**RE: MARSDEN PARK PUBLIC SCHOOL
 MARSDEN PARK, NSW
 STATE SIGNIFICANT DEVELOPMENT (SSD9809)**

The following letter is written in response to Requests for Information (RFIs) raised by Blacktown City Council dated 28/04/20 regarding the State Significant Development Application for the New Marsden Public School, Marsden Park. The letter aims to satisfy concerns relating to the civil engineering matters raised by Council's Drainage Engineers.

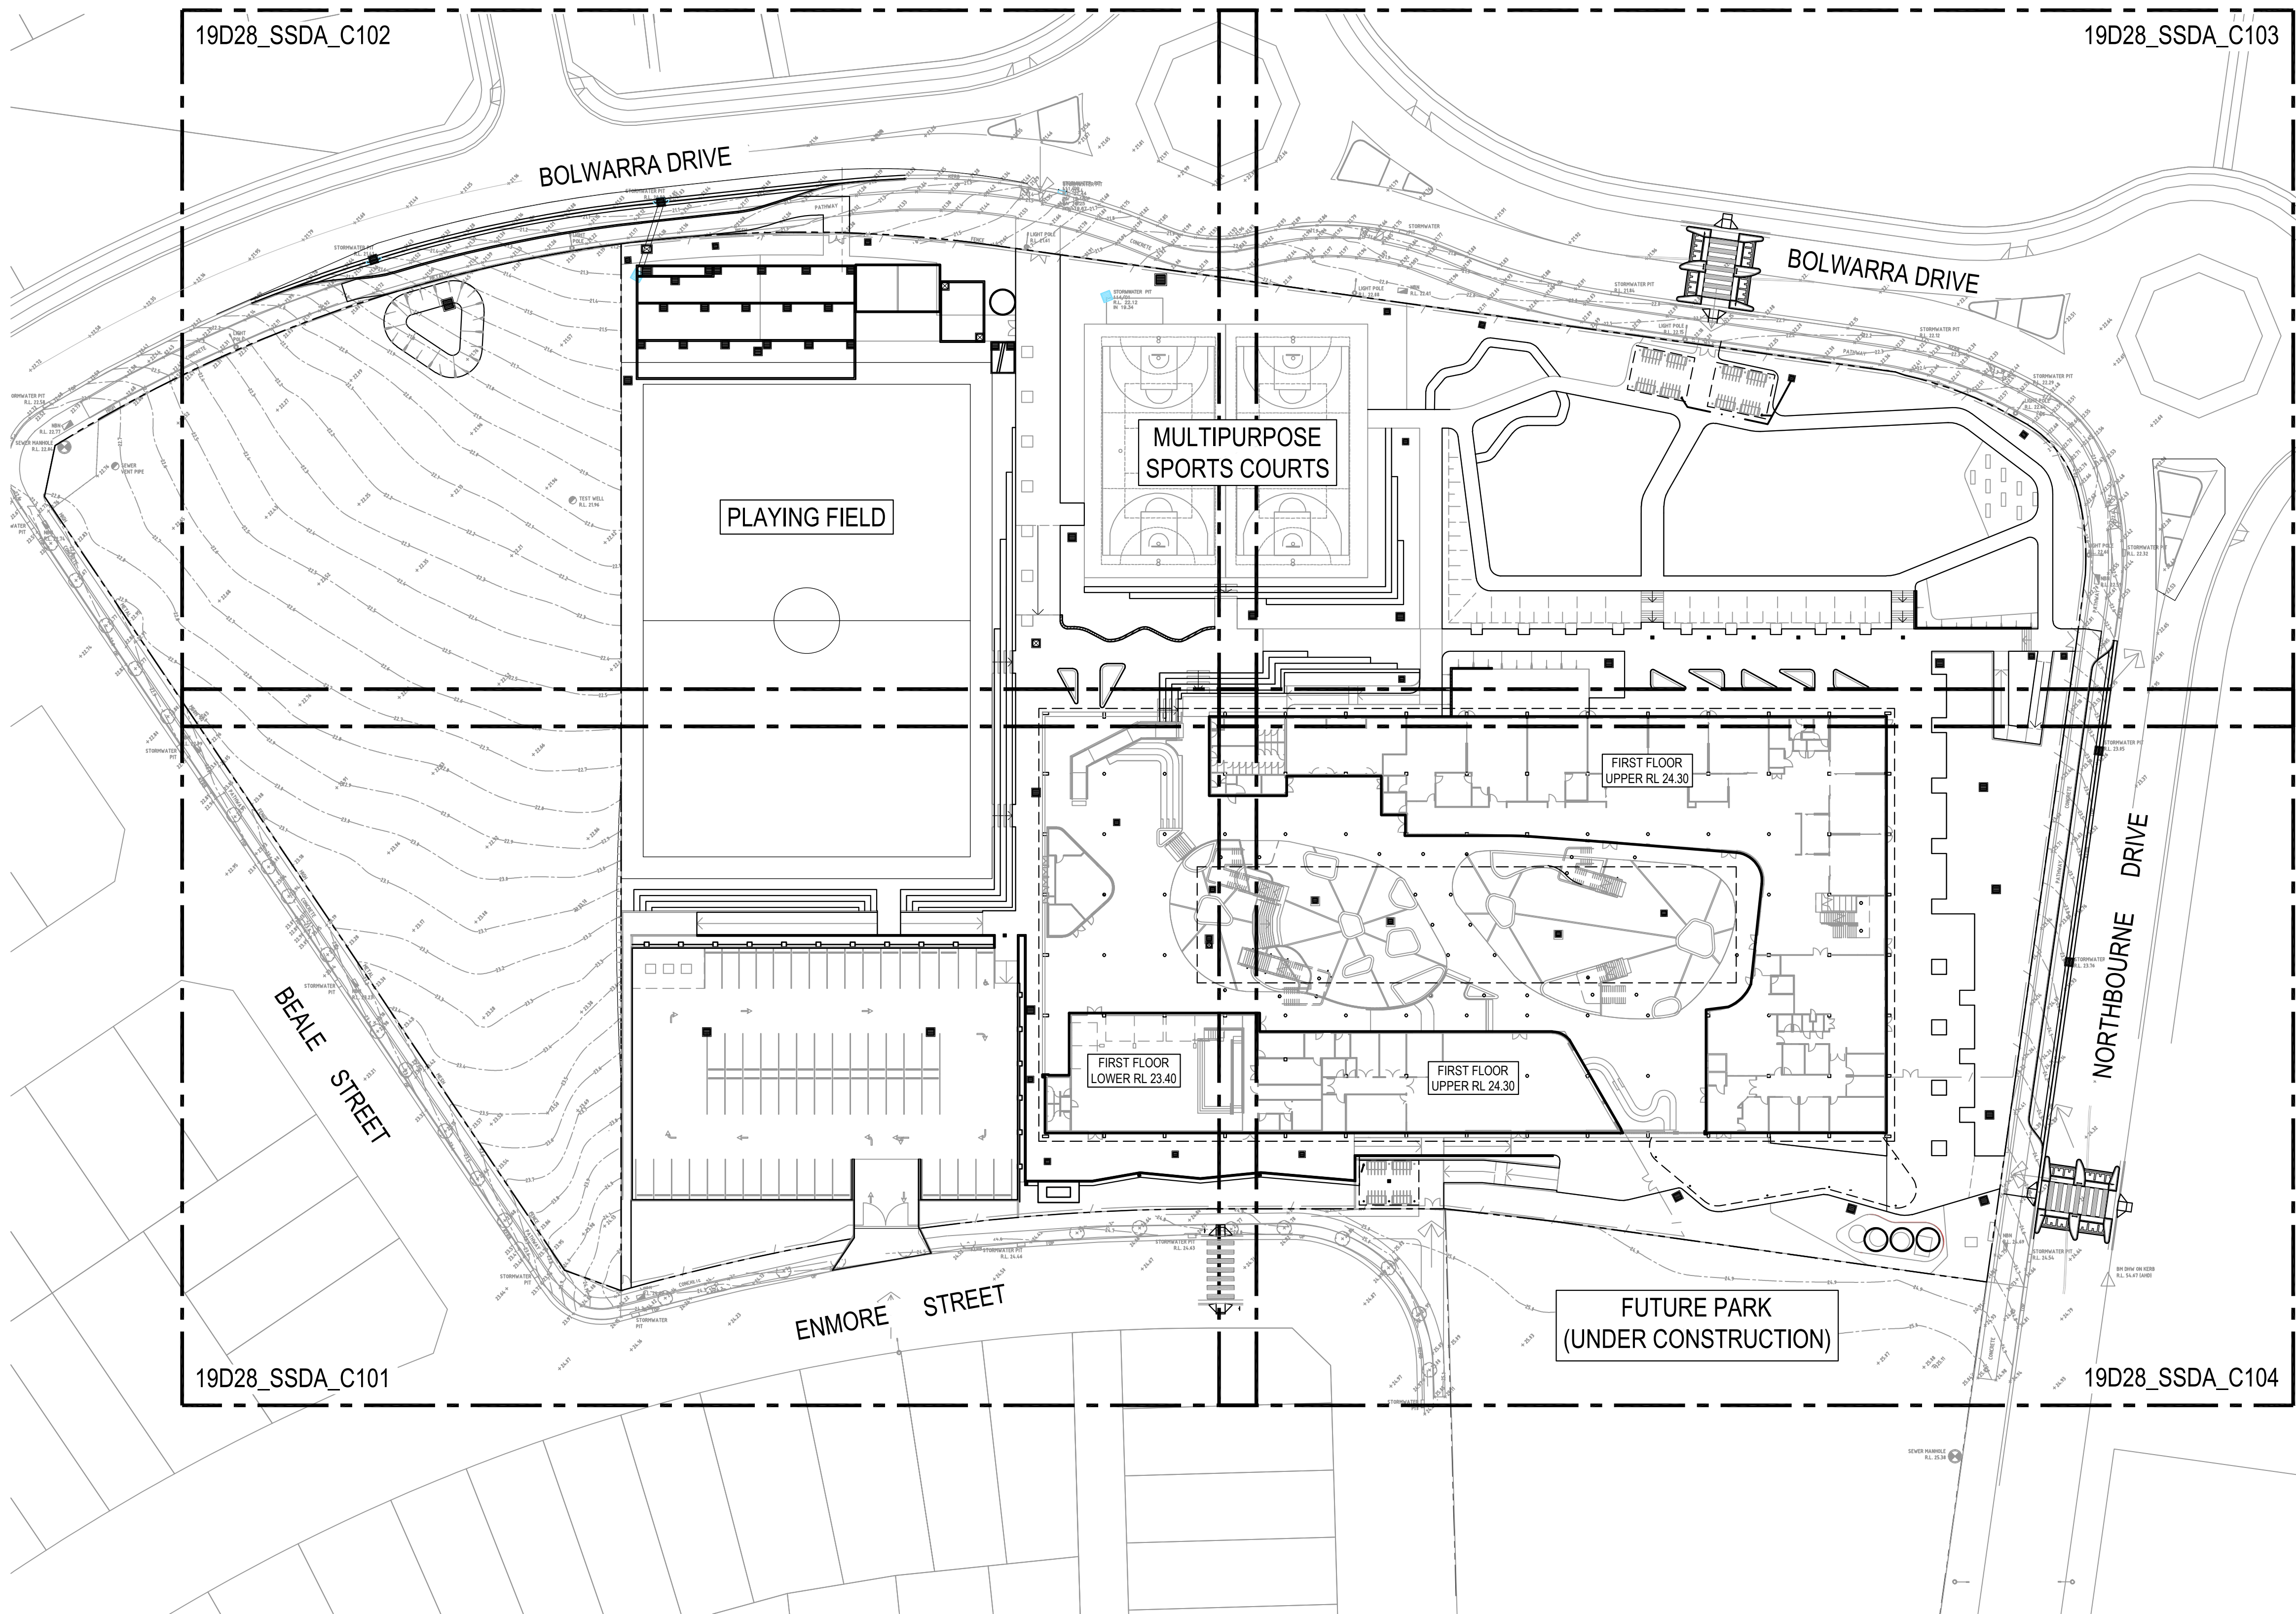
1. Amend Dwg. No. C101 (04):
 - i. Provide the RL of pit C-1
 - ii. Ensure a minimum freeboard of 100mm between the internal and external areas such as pits B-7 to B-9. The internal first floor RL is 23.40 while the average levels of the aforementioned pits is 23.35.
 - iii. The architectural plans by NBRS Architecture, dated 5.03.20, Rev.C, Dwg. No. A-100 shows a kerb profile that surrounds pits E-1 and E-2. Pits are to be free from obstruction that may prevent surface flows from being collected. Relocate the pits, remove the kerb profile or provide a 'hit and miss' kerb if required.

1.i. A level has been provided for pit C-1, refer revised drawing 19D28_SSDA_C101.

1.ii. Drawings have been updated to provide a minimum freeboard of 100mm between internal and external areas. Surface levels of B-7, B-8 and B-9 have been updated to RL 23.28 to provided 100mm freeboard between pit surface level and first-floor level. Refer to revised engineering drawings 19D28_SSDA_C101-C104.

ORIFICE CALCULATIONS

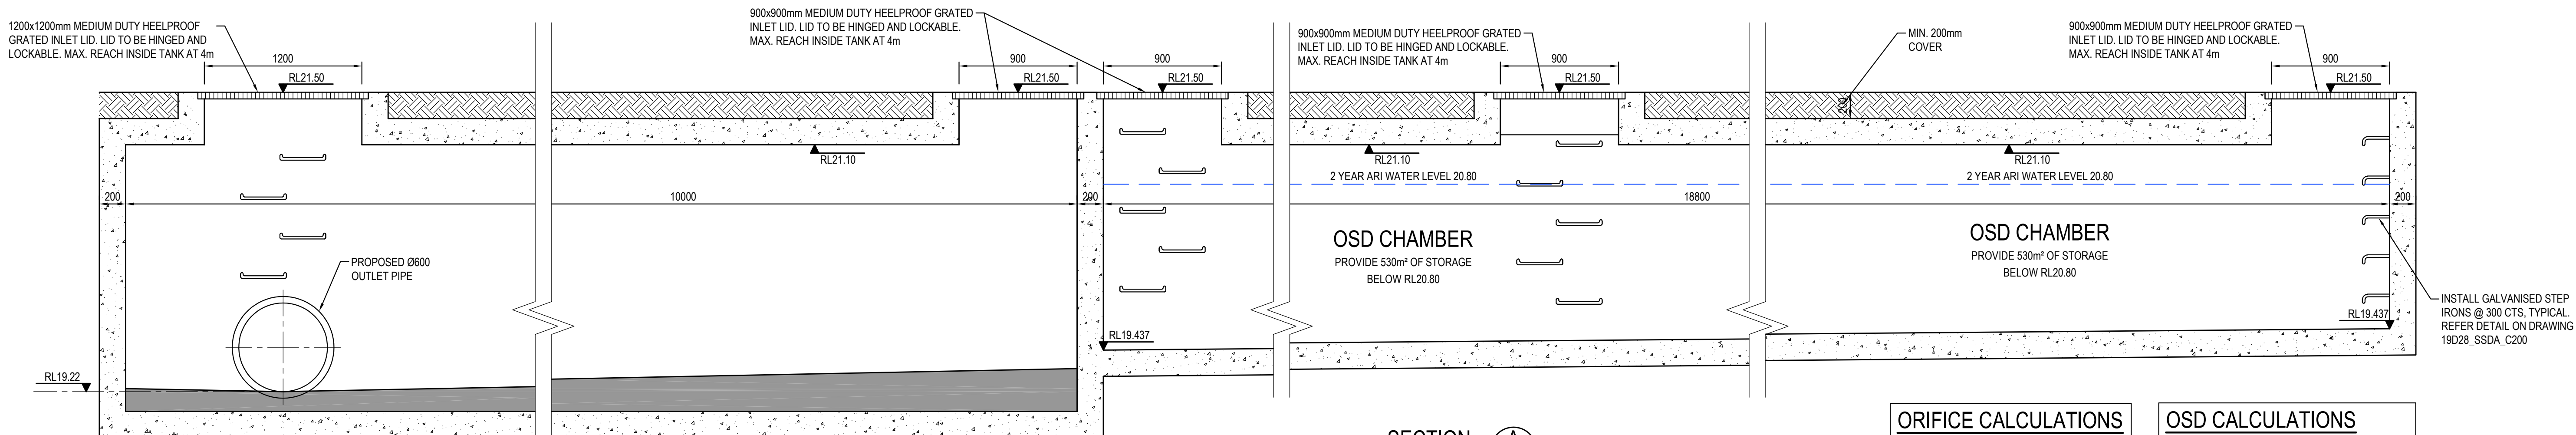
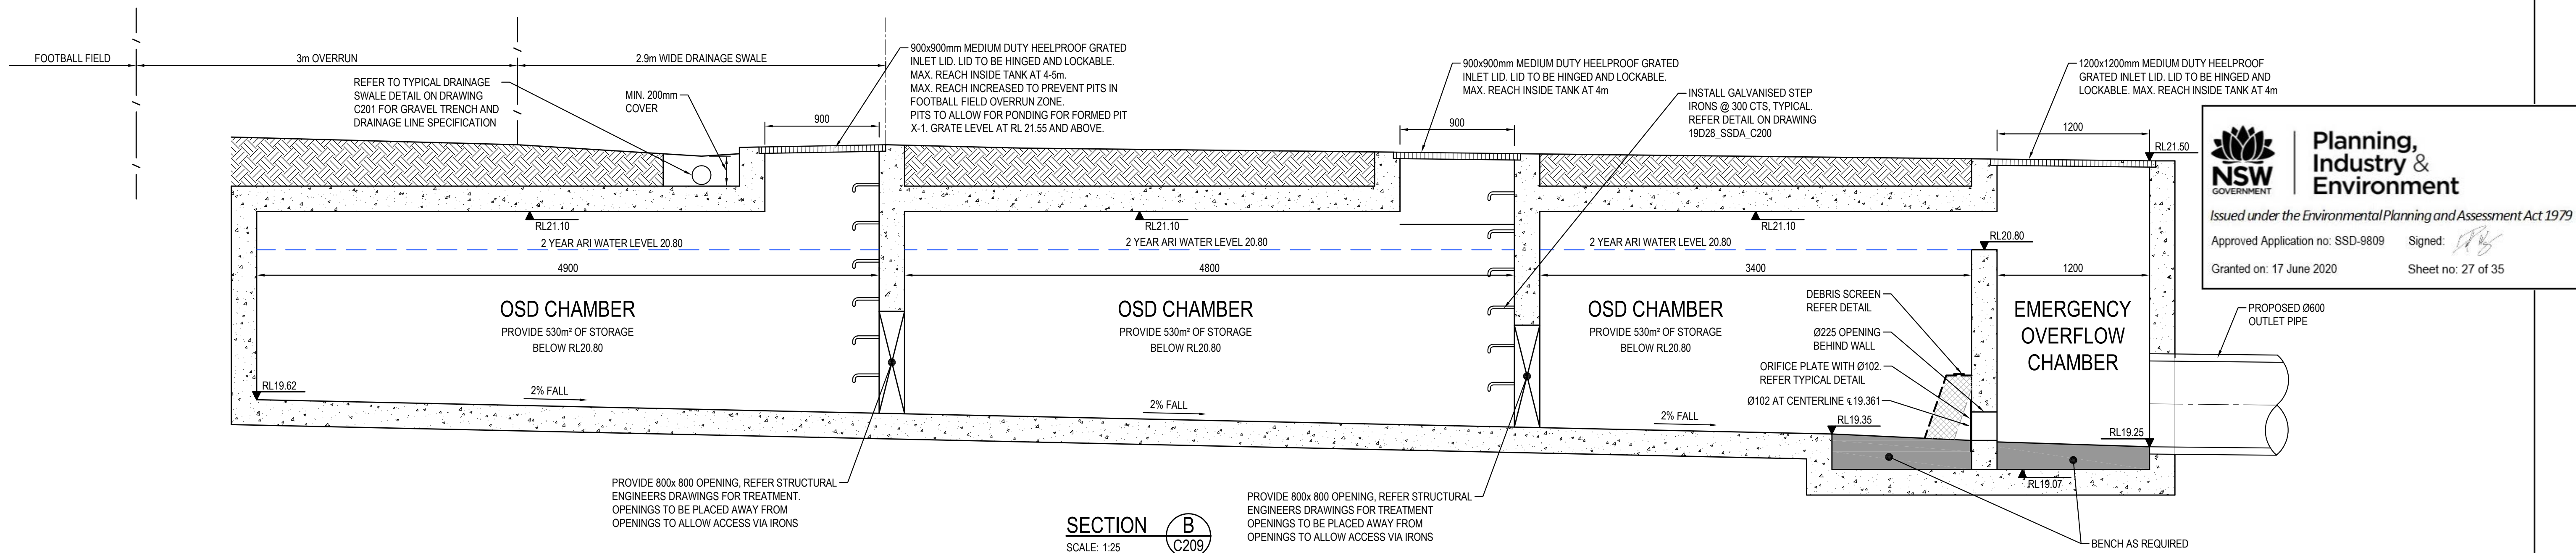
4. Amend Dwg. No. C210 (03):
 - i. Section A - Delete the 2yr TWL from the overflow chamber.
 - ii. Provide OSD design volume calculations including average height and area of OSD.
 - iii. Provide the OSD Orifice and Weir calculations

4.i. Section A has been amended, the 2-year TWL has been removed from the overflow chamber. Refer revised engineering drawing 19D28_SSDA_C210.

4.ii. OSD volume calculations have been provided. OSD layout has been amended for an overall increase in the internal width (and storage volume) of the OSD tank from 14.5m to 14.9m to allow for loss of storage by the OSD structure. Refer revised engineering drawings 19D28_SSDA_C210 and C209.

4.iii. Orifice and weir calculations have been provided on revised engineering drawing 19D28_SSDA_C210 and C212.
